From: Simon Davis
Sent: 03 July 2019 11:57
To: Nick Hopper <[REDACTED]>
Subject: RE: BR/129/19/PL 75

Please find attached revised site plan which we trust addresses concerns as to the viability of the second parking space in relation to the above listed application. I have tried to contact Debbie Farrelly in Highways for some clarification of her consultation advice as I note there does not appear to be any concerns in relation to our Lambeth methodology traffic survey.

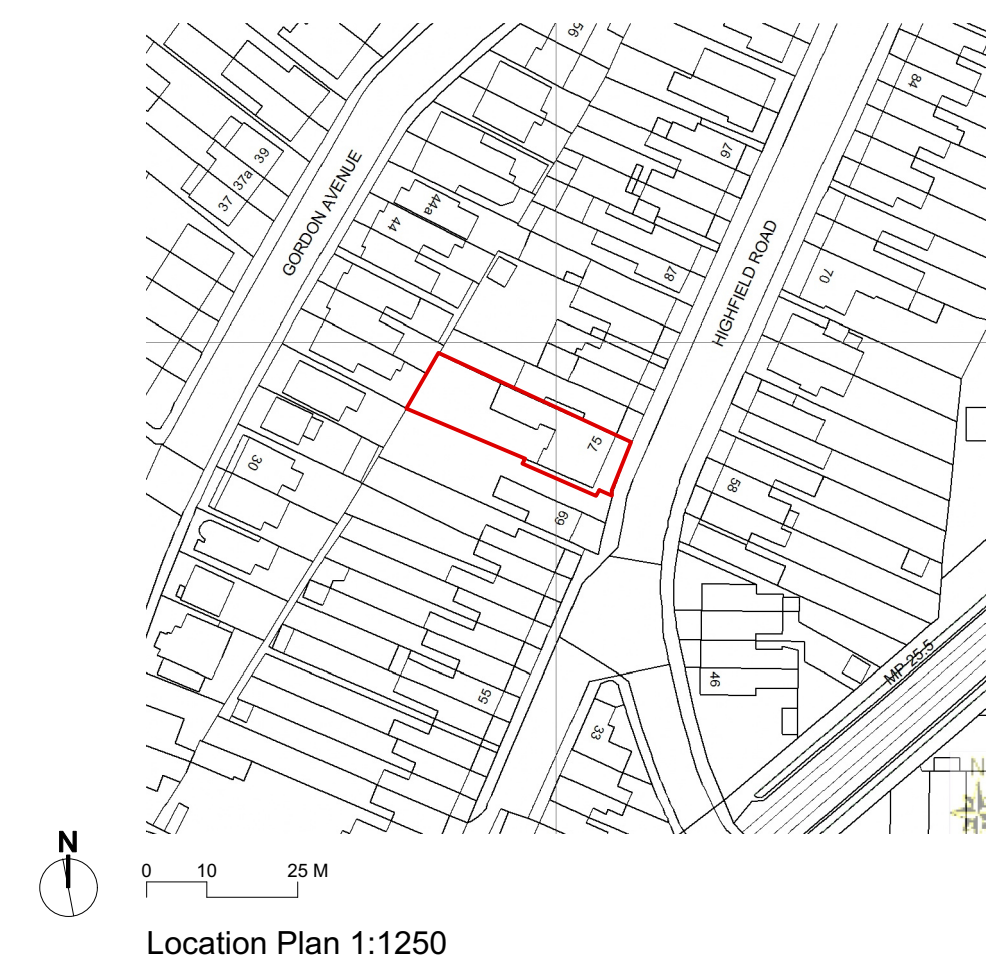
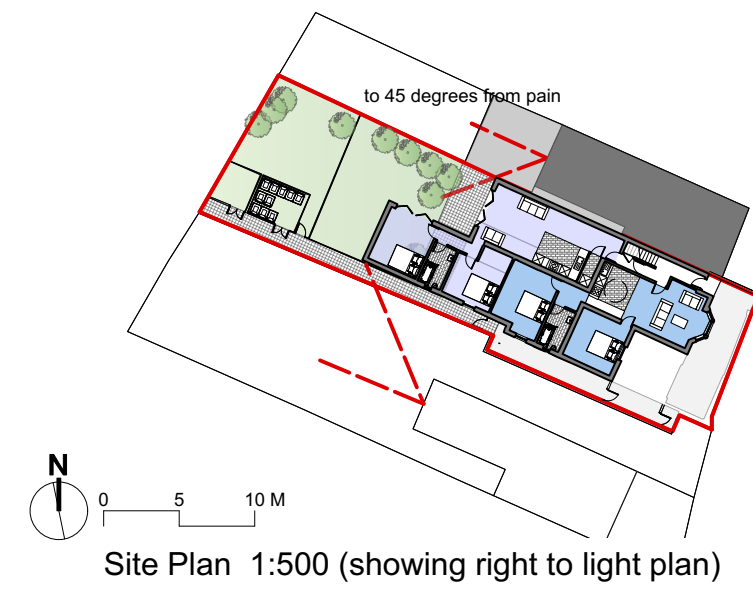
Thank you for this. We will upload this revised plan. However, this will not remove the concerns about access to the space unless you can also (a) demonstrate that you have consent to move the telegraph pole (I assume you would obtain this from BT?); and (b) demonstrate that the section of wall to be removed is in your clients ownership.
